Our Case Number: ABP-319843-24

Re: Proposed development for a Facility Centre for Water Based Activities.
Magherabeg Beach, Castlegregory, in the townland of Magherabeg, Co. Kerry.

Re: Approval for a Facility Centre for Water Based Activities at Magherabeg Beach, Castlegregory, Co. Kerry in the townland of Magherabeg

TITLE: PROPOSED FLOOR PLAN LAYOUT

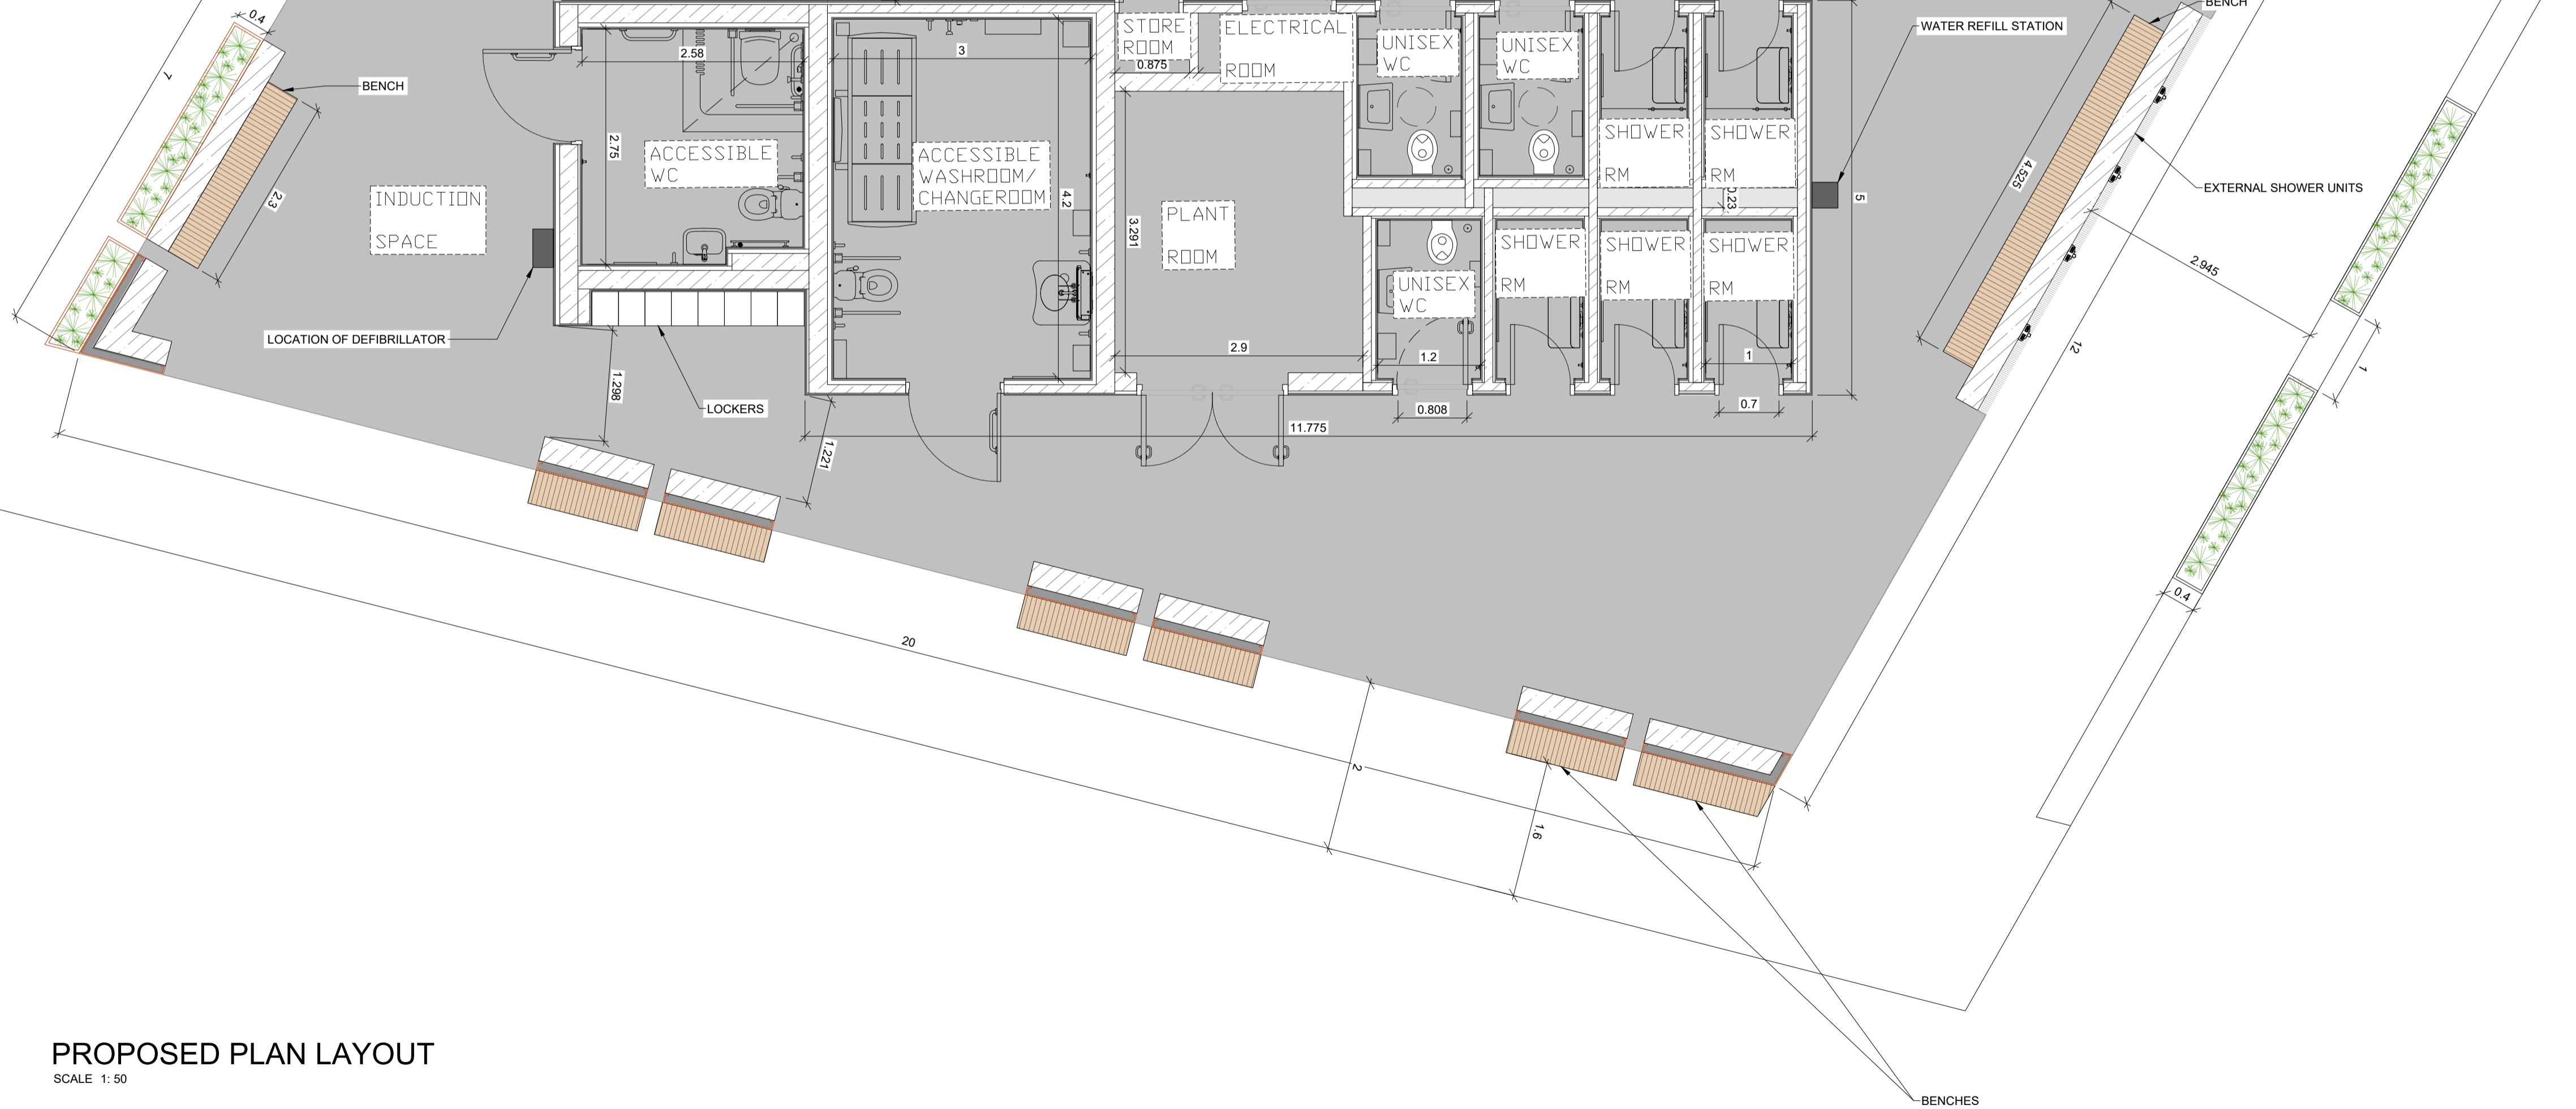
- (d) Noise: It can be seen on the drawings that there is a large plant room proposed. It can be reasonably expected that increased noise levels will emanate from the proposed facility and that such noise will negatively impact on persons within the curtilage of Mrs. Moyles dwelling. Of greatest concern is the noise that will undoubtedly be generated late in the evening and into the night by groups of teenagers who will now have a place to congregate and to party.

TITLE: **PROPOSED BUILDING ELEVATIONS**

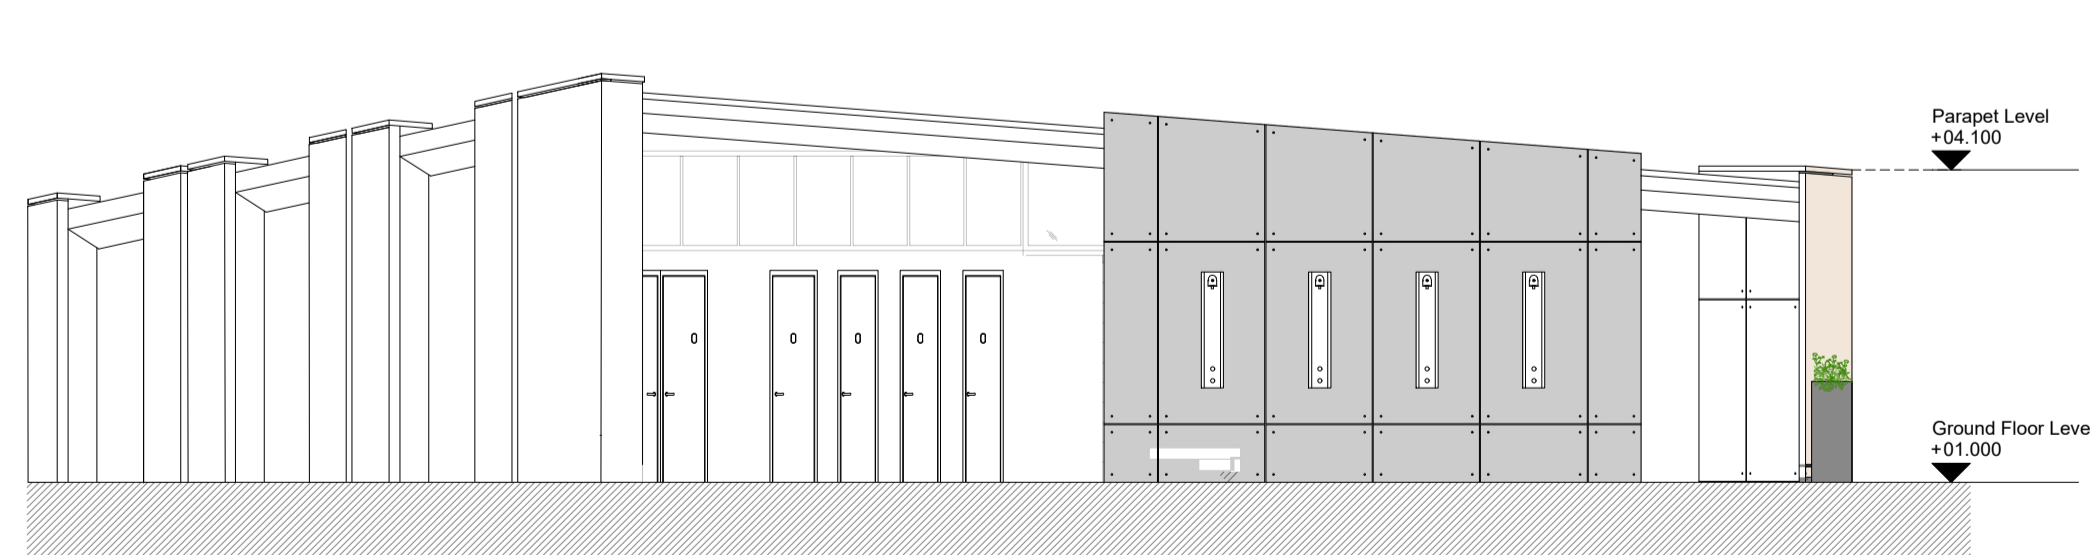
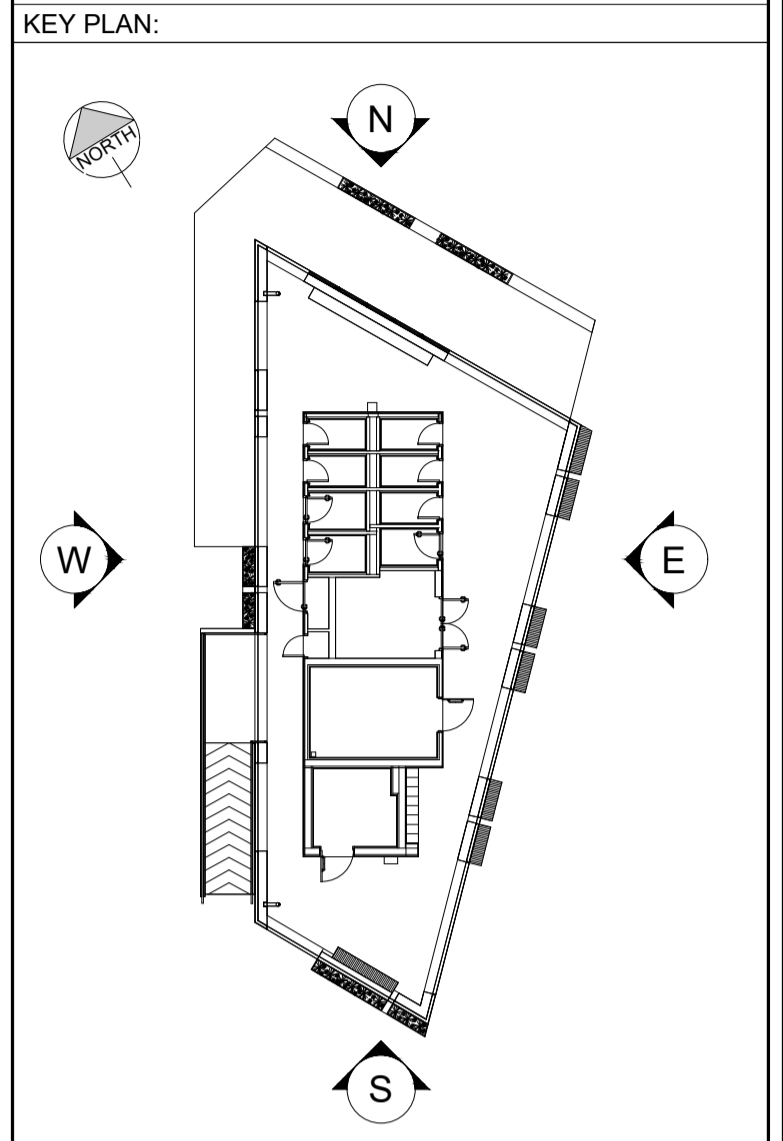
The height of the proposed building appears to vary from between 3.1m to circa 5m.

- (a) Visual impact:: The proposed structure does not fit well into its surrounding environment, rather it leads to a confused vista when viewed from the northern or the southern approaches.

- (b) Scale: The scale of the proposed building is completely out of proportion when compared to the existing structure ie Mrs. Moyles' dwelling.
- (c) Dominance: When viewed from Mrs. Moyles' site the structure is read as a very high and very long wall on her southern boundary. This will frequently appear to be a very dark and overbearing structure and will particularly damage the Moyles Family's enjoyment of their front garden due to its dominance.
